MIDTOWN COLLECTION AT HANNAH RIDGE FILING NO. 1

A REPLAT OF TRACT BB OF HANNAH RIDGE AT FEATHERGRASS FILING NO. 1, RECEPTION NO. 214713468, RECORDS OF EL PASO COUNTY, COLORADO, SECTION 32, TOWNSHIP 13 SOUTH, RANGE 65 WEST OF THE SIXTH PRINCIPAL MERIDIAN, EL PASO COUNTY, COLORADO

SF-19-007

MIDTOWN COLLECTION AT
 HANNAH RIDGE FILING NO. 1
 JOB NO. 1116.30
 JANUARY 15, 2019
 SHEET 2 OF 3

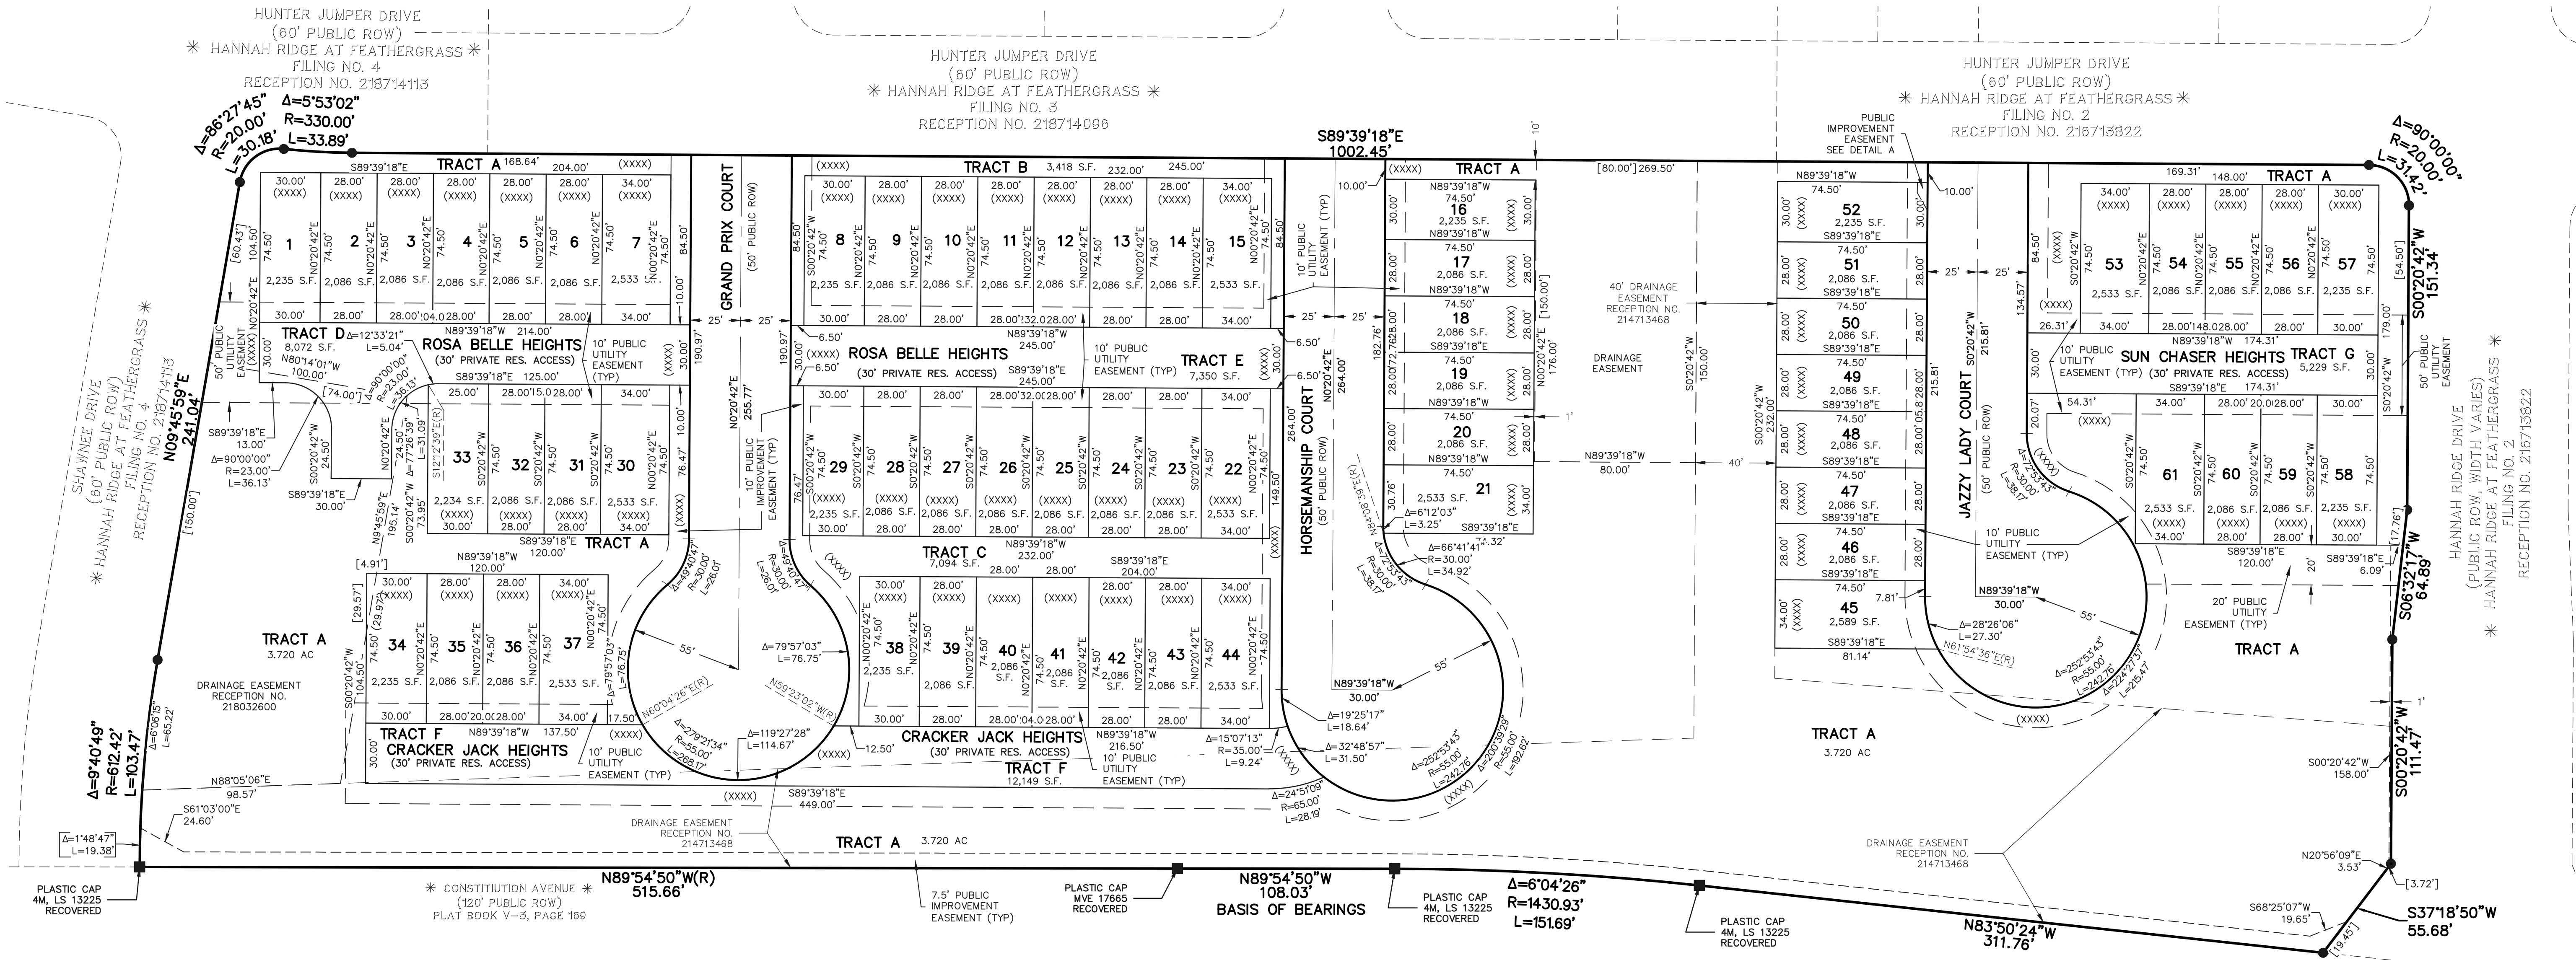
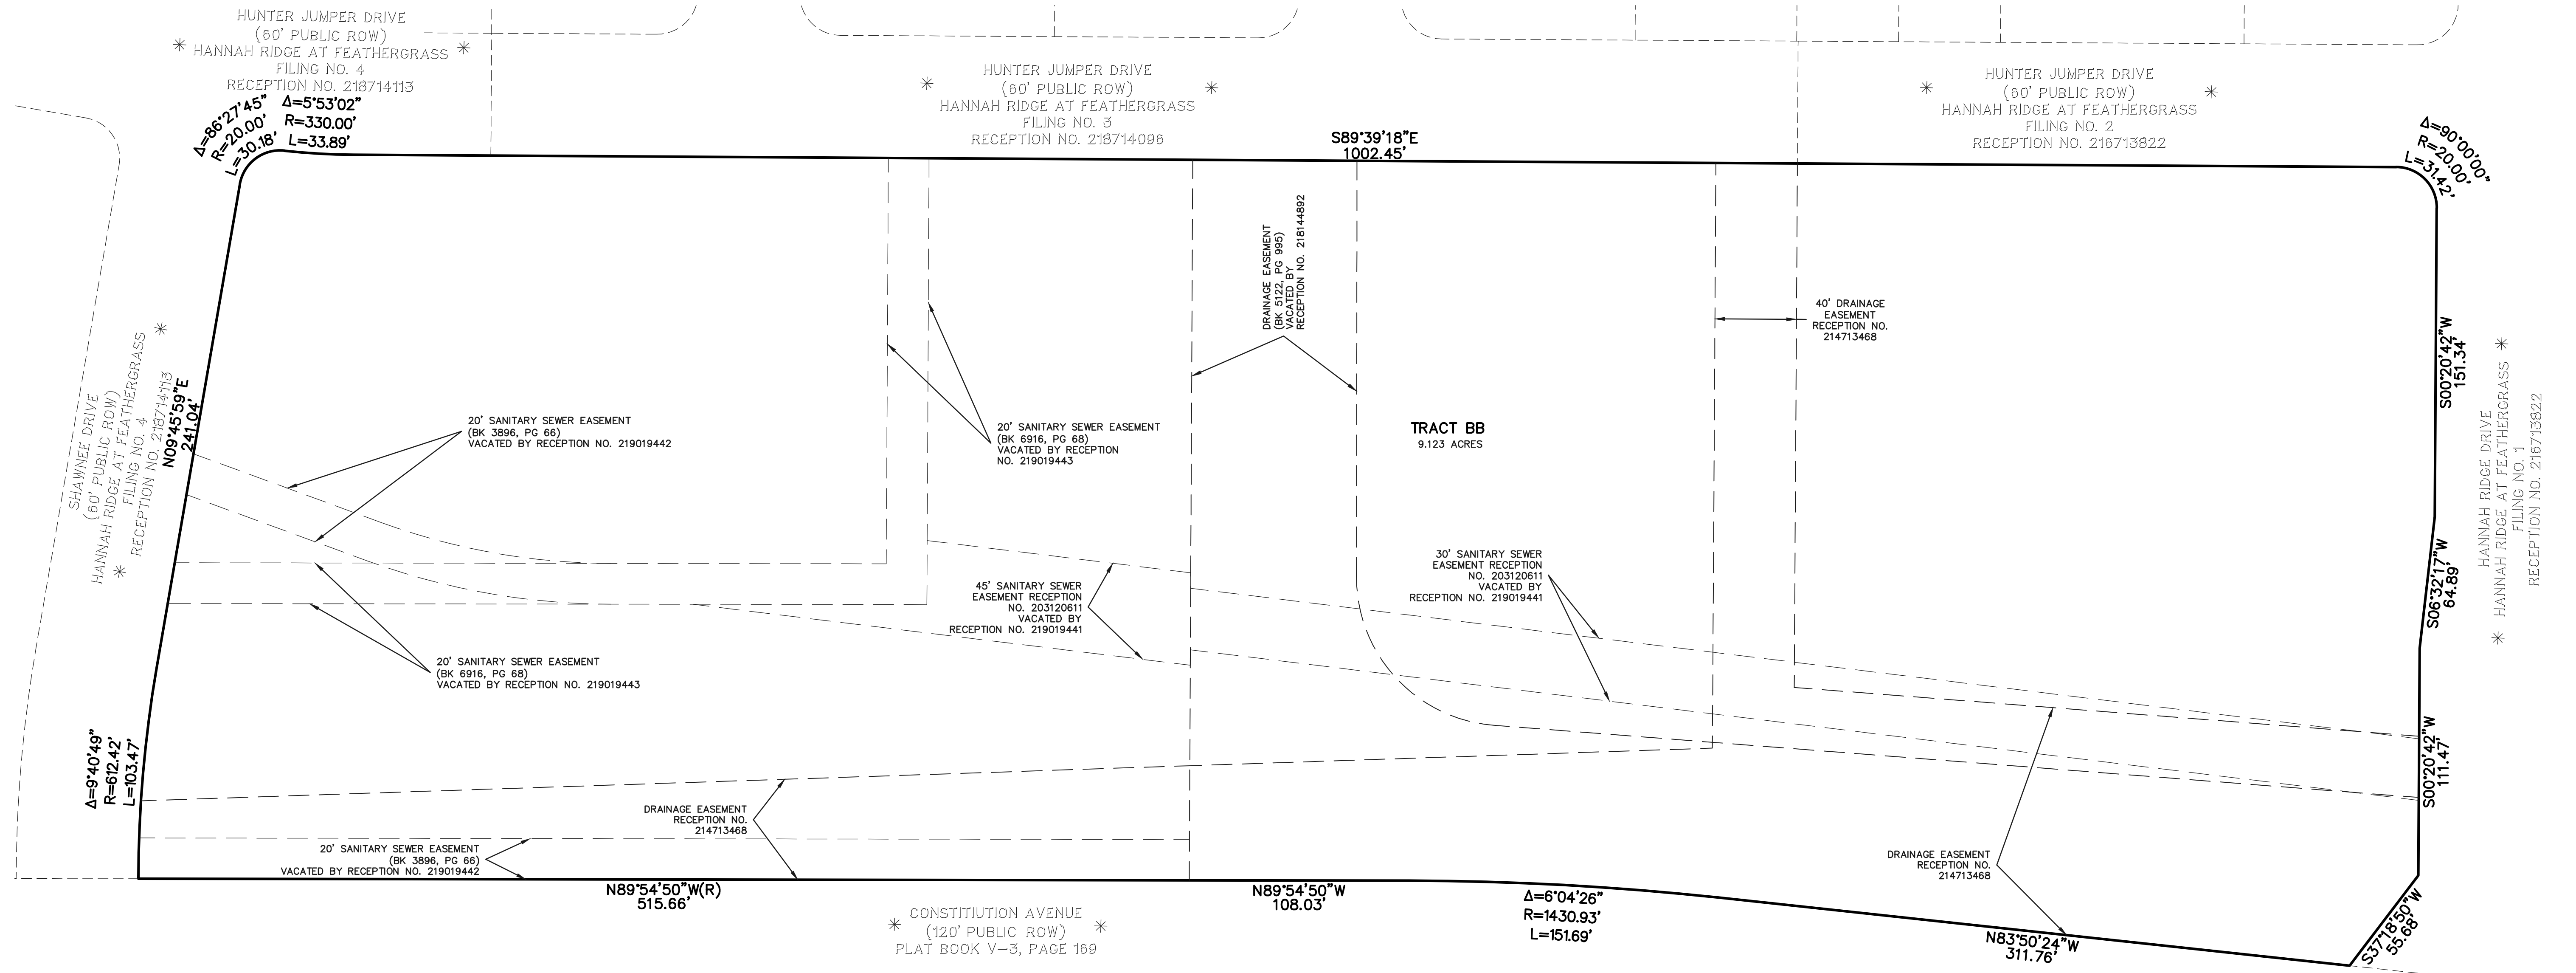
Is this a public drainage easement?
 The Filing 1 plat didn't specify. Note
 who the easement is to.
